RE: PLANNING APPLICATION 3/2024/0143 - 1 MEADOW CROFT, WEST BRADFORD BB7 4TJ

The application in question seeks retrospective approval for the construction of a car port to the front of the property. The Parish Council would wish to make the following observations on this application:

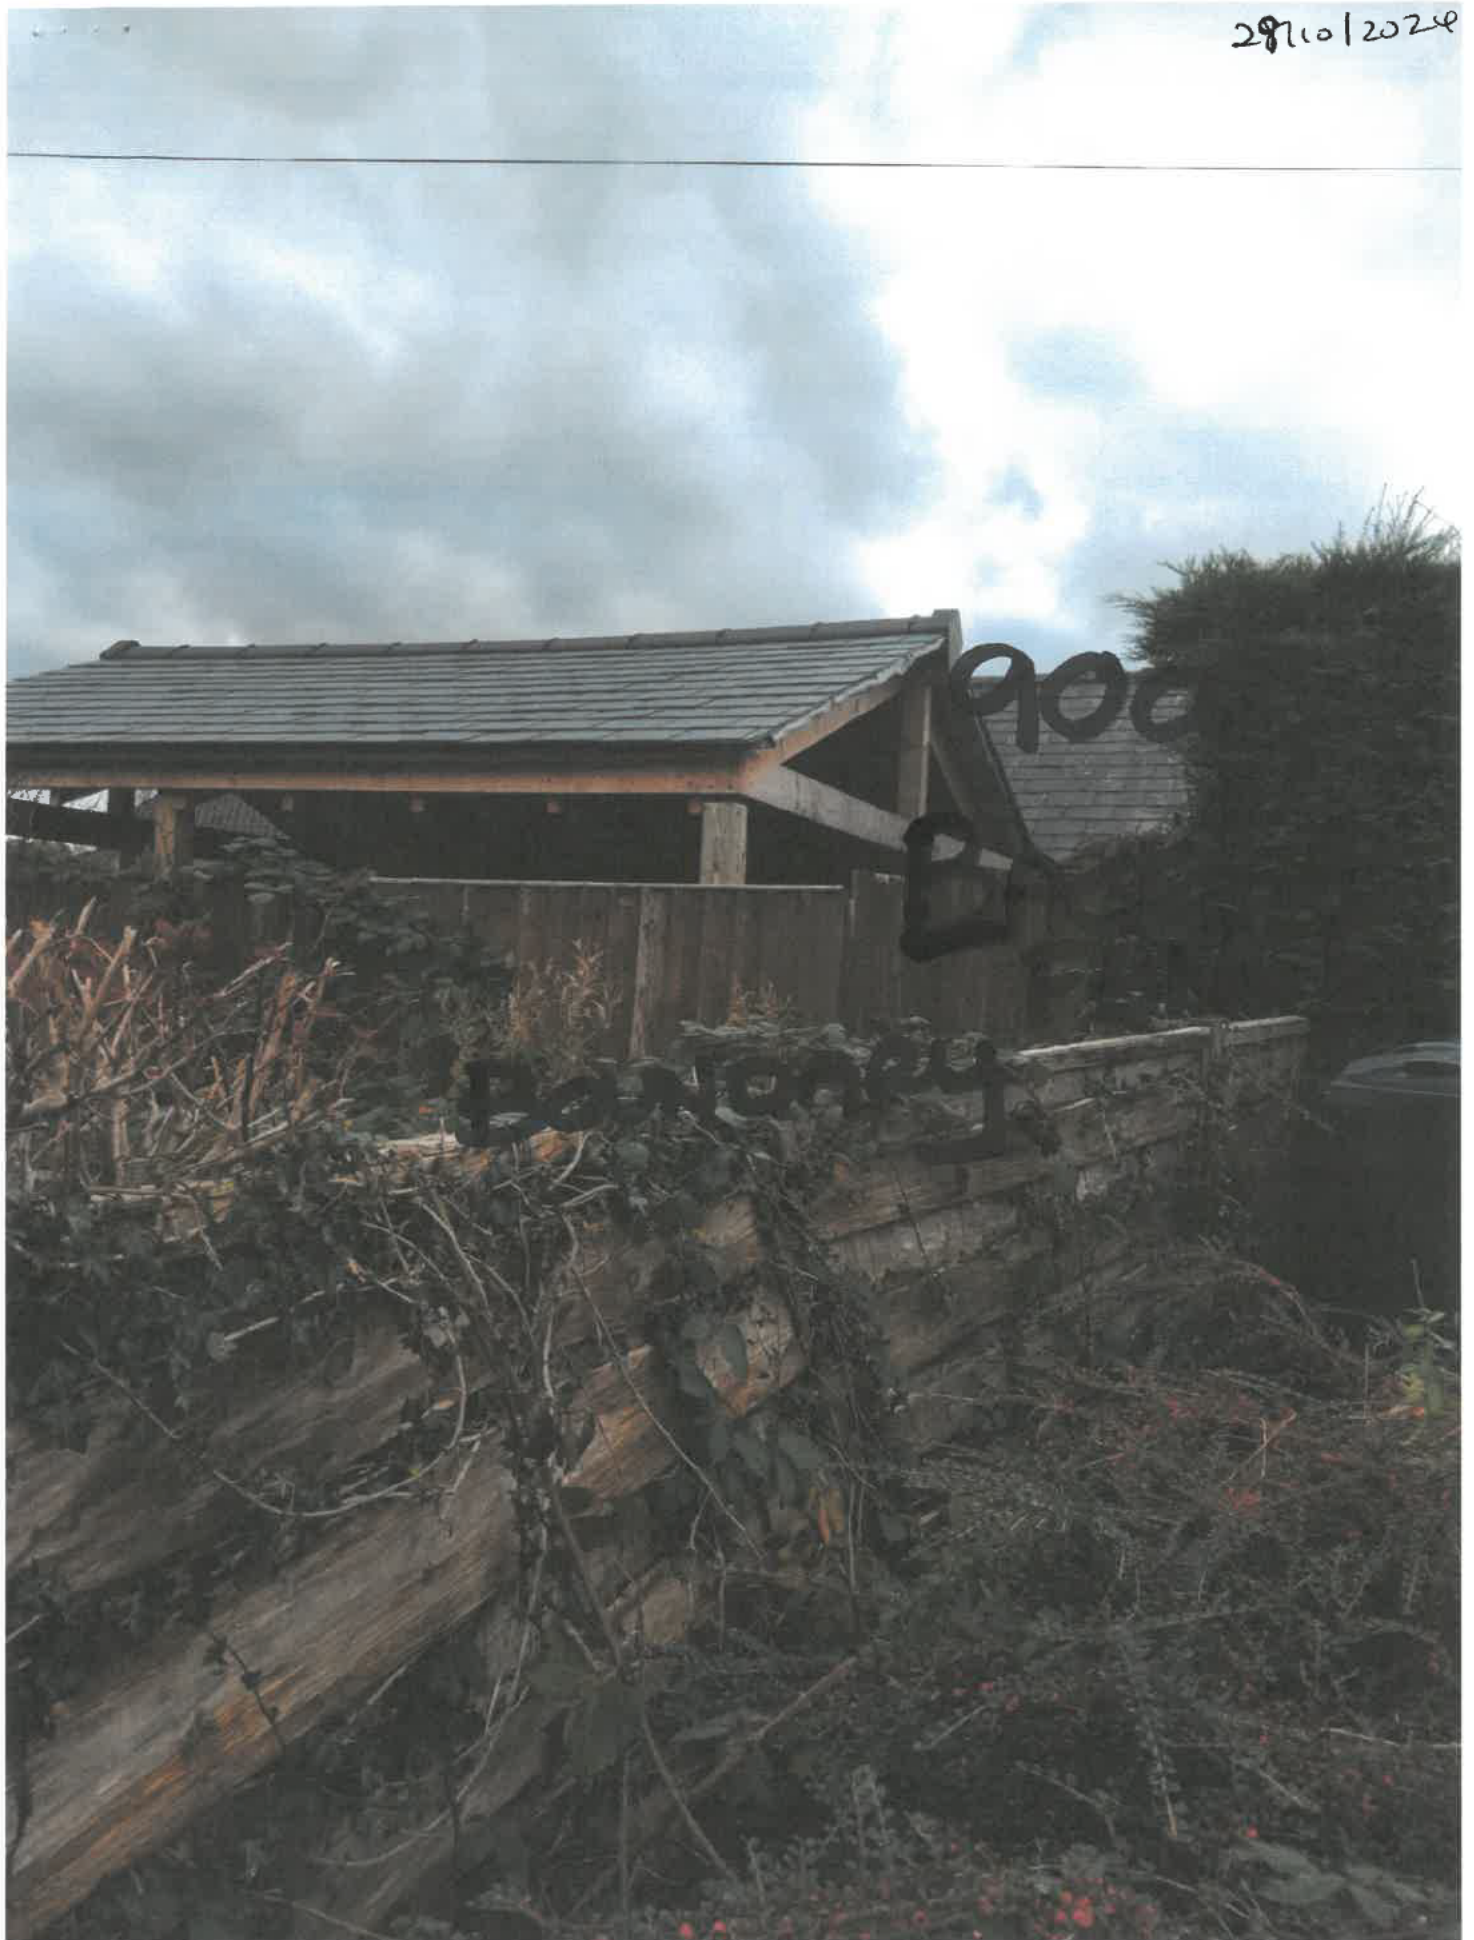
The car port is therefore highly visible to many residents and visitors to the village. Members believe that its aesthetic appearance would be considerably improved if it were to be made of similar materials to the two adjacent garages already present. Unfortunately, the structure is both wooden-framed and open-sided, in marked contrast to the surrounding buildings. This is illustrated by the applicant's own photograph (below), submitted as part of the application.

Should consent be granted, members believe that this development would have an adverse visual impact on residential amenity;

For the above reasons, the Parish Council would oppose this application in its current form. Should consent be granted, members would wish to see (i) the design / appearance of the structure being made more sympathetic to its immediate surroundings and (ii) their concerns around tidiness addressed. The Parish Council notes that the last date for submission of comments is 26 November 2024, and would be grateful if the above comments could be considered when Planning Application 3/2024/0143 is determined.
